M3 Junction 9 Improvement Scheme – TR010055

Reference: M3J9-EIA064

For Deadline 5 (D5), the South Downs National Park Authority (SDNPA) would like to make the following submissions.

Appendix A

Appendix F Cross section of compound

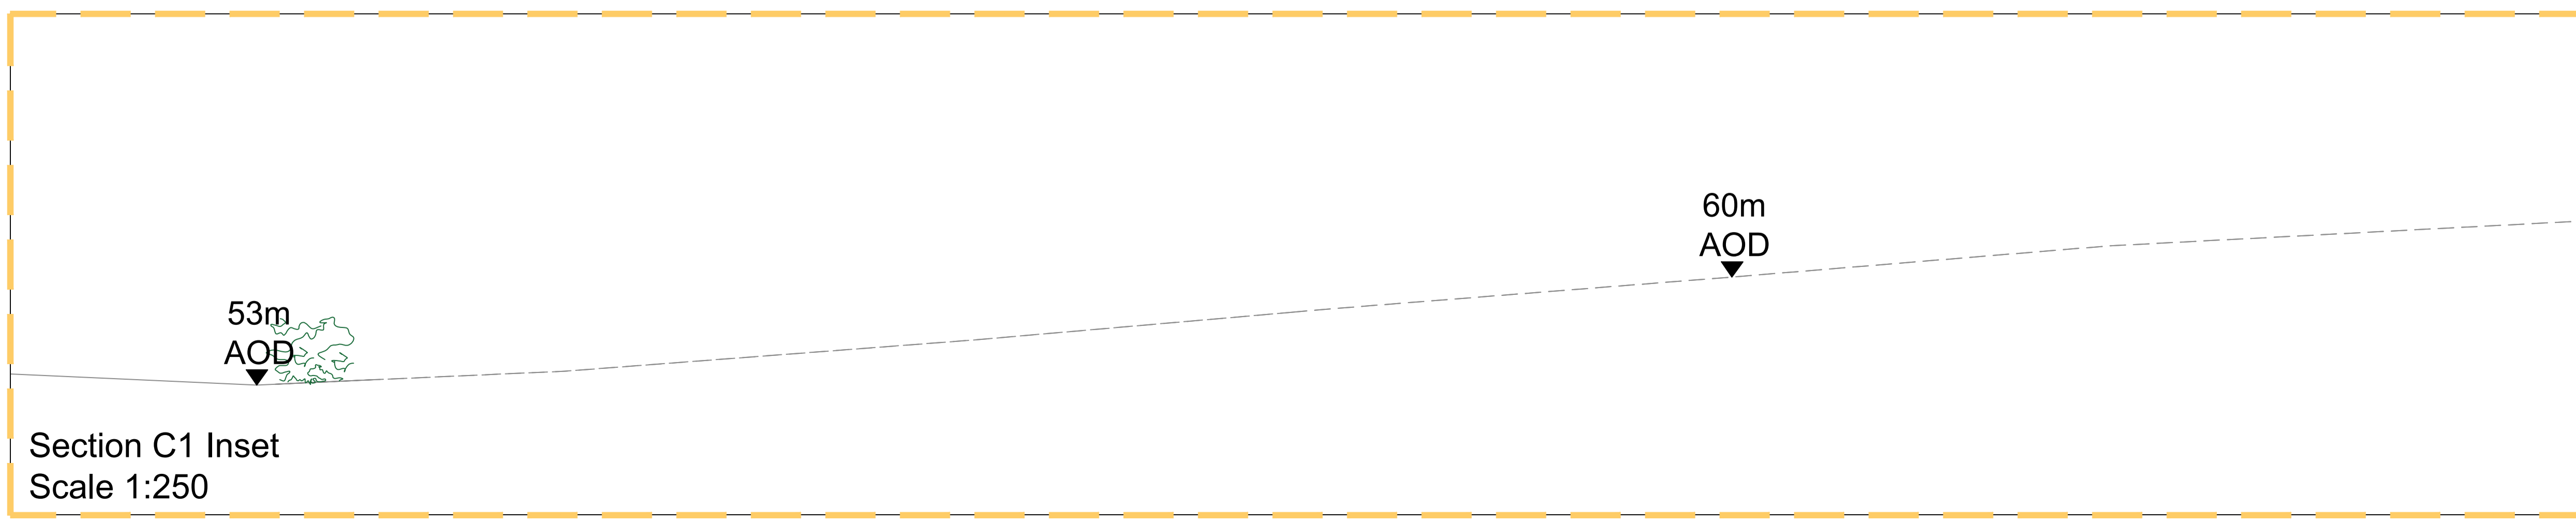
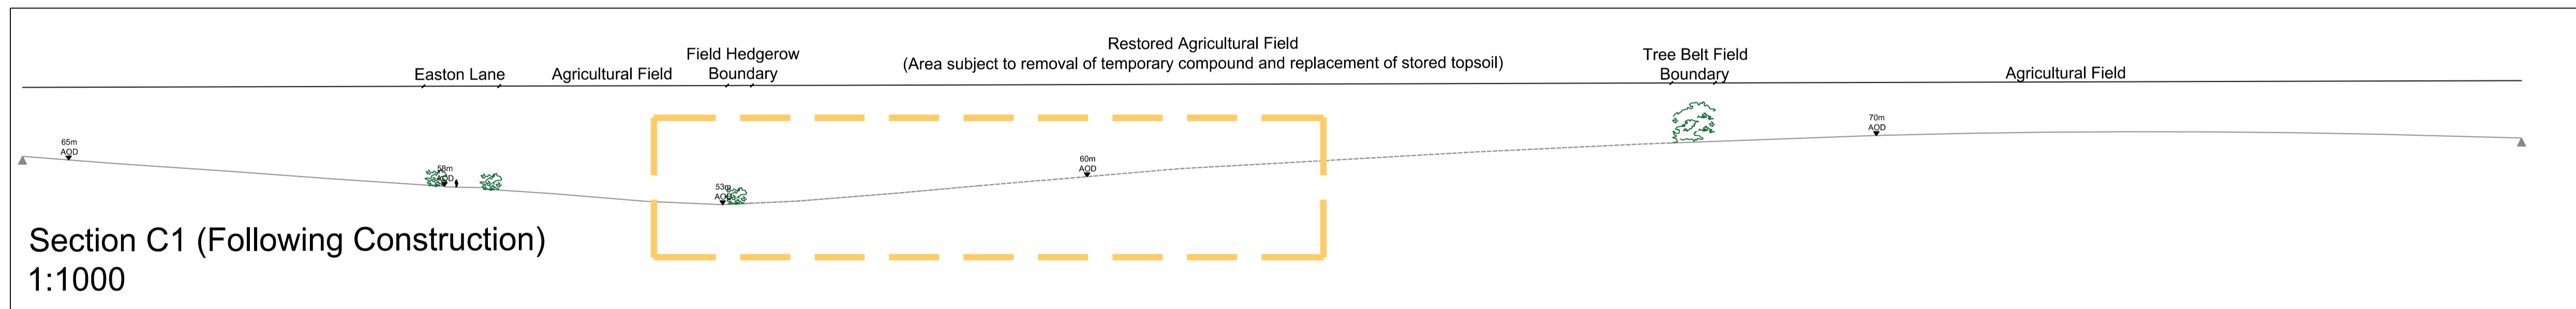
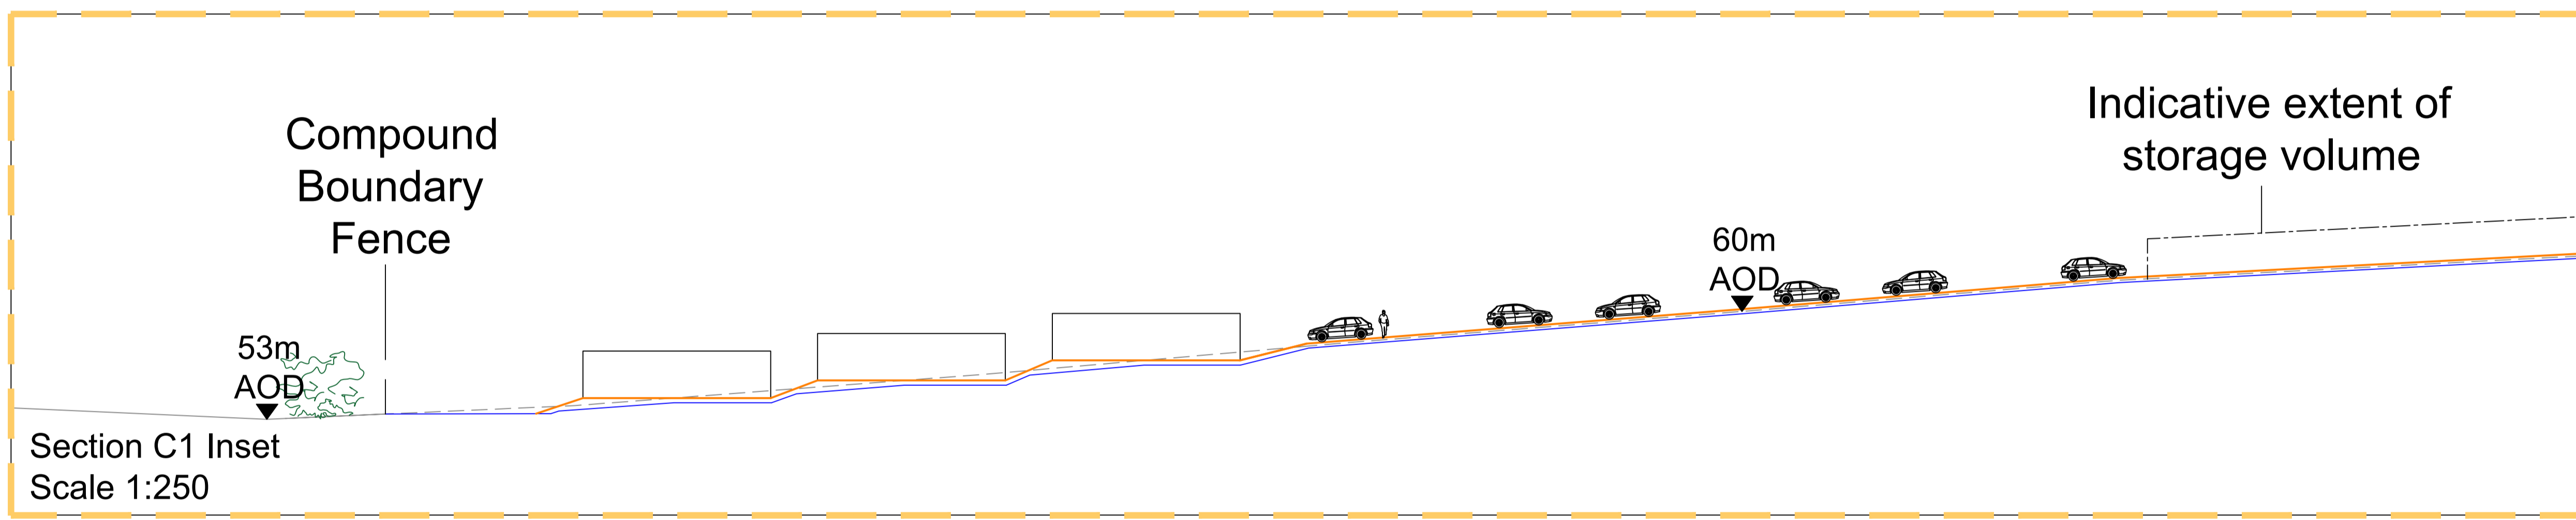
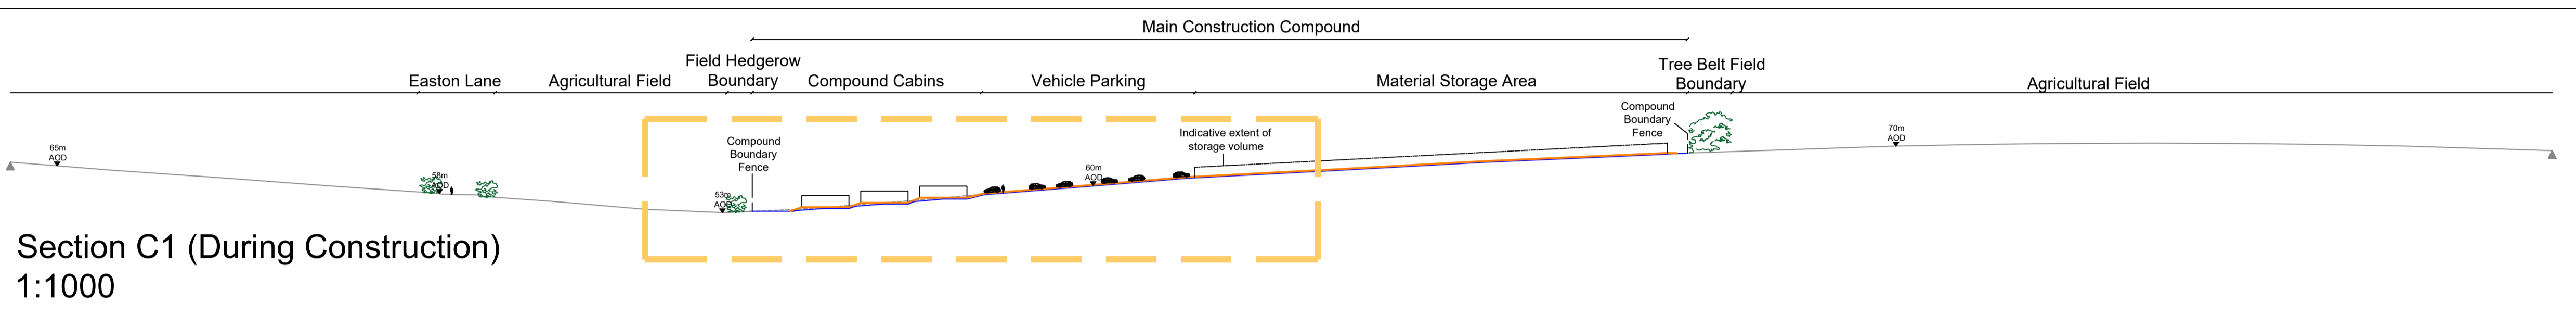
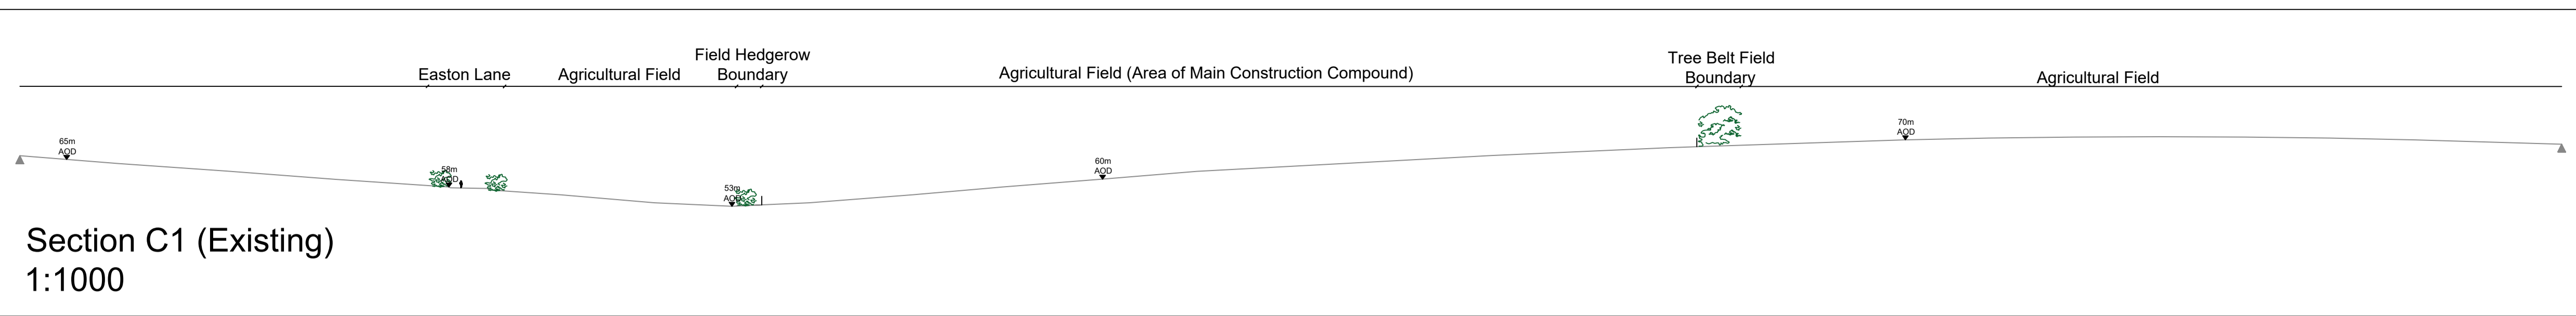
Question Reference	Examining Authority Question	SDNPA Response
		<p>Appendix 7.6: Outline Landscape And Ecological Management Plan</p> <p>This needs further clarification and / or the documents need to be amended.</p>
Q12.2.6	<p>The Applicant’s written summary of oral submissions for ISHI [REP4-034] Appendix F provides cross-sections of the proposed construction compound. The sloping nature of the site is shown as varying between 53m and 60m AOD where the vehicles are parked. Appendix C – Construction Compound Position Paper Table 1: Construction operations and actions paragraph 141 states that: “The location of the cabins in a low-lying area of land that will have minimum visual effect has been prioritised over locating areas not requiring a cut and fill area that might be more visible”.</p> <p>In addition, paragraph 1.5.5 states that: “The location of the proposed cabins at the lower ground level to the north of the compound reduces the visibility of these temporary structures.”</p> <p>(i) Given the sloping nature of the site would the cabins, parking and storage areas be apparent from surrounding higher ground including to the north, and east. Please explain the extent and aspects of the construction site that you anticipate would be seen from within the SDNP and its setting and from Easton Lane.</p>	<p>There have been no further discussions with the applicant on this issue.</p> <p>The cabins which are located on the lower land are up to 3.5m high, but the storage which is located on the higher land is also up to 3.5m. The storage may be less permanent than the cabins but it has the potential to appear more cluttered. Both cabins and storage will be visible from Easton Lane within the SDNP. They will be seen beyond the 2.2m close boarded fence which in itself will appear incongruous. It is accepted that the close boarded fence will screen views of parked cars.</p> <p>However, the Compound layout plan in Appendix D does not show the entrance from A272, whether that will require any vegetation removal and where the office mentioned in paragraph 1.3.17 will be located.</p> <p>If the Examining Authority agrees to Site A for the Compound, then yes the SDNPA would like to see the DCO amended to include height limits and prevent the use of double storey units.</p> <p>The SDNPA would also like to see a commitment to the use of ‘living hoardings’ (as referred to in response to Q.12.2.3) and further mitigation through the use of the Construction Worker Travel Plan to further reduce the amount of car parking required on Site A.</p>

Question Reference	Examining Authority Question	SDNPA Response
	<p>(ii) Please provide an AOD for the boundary of the proposed construction site nearest the M3 and confirm that the slope would only be altered to the limited extent shown and explain how this would be secured by the draft DCO.</p> <p>(iii) The Appendix C plan shows different areas being used for the compound cabins, vehicle parking and material storage. Whilst it is noted that the plan is marked as indicative, please explain how the different usages of parts of the site would be controlled and defined.</p> <p>(iv) Whilst the Applicant anticipates that the car parking and material storage would be lower in height than the cabins, given the SDNP location should all activities on the site be subject to height limits secured by the draft DCO including the heights of the compound cabins and the storage and the avoidance of double storey office units.</p> <p>(v) The Applicant [REP4-034] confirms that it would continue discussions with the SDNPA over the extent of further mitigation that could be required including whether providing limitations and/or parameters to the heights of buildings and storage of materials may resolve the SDNPA's concerns. Please provide an update in relation to such discussions and set out any consequent draft DCO amendments that are sought.</p>
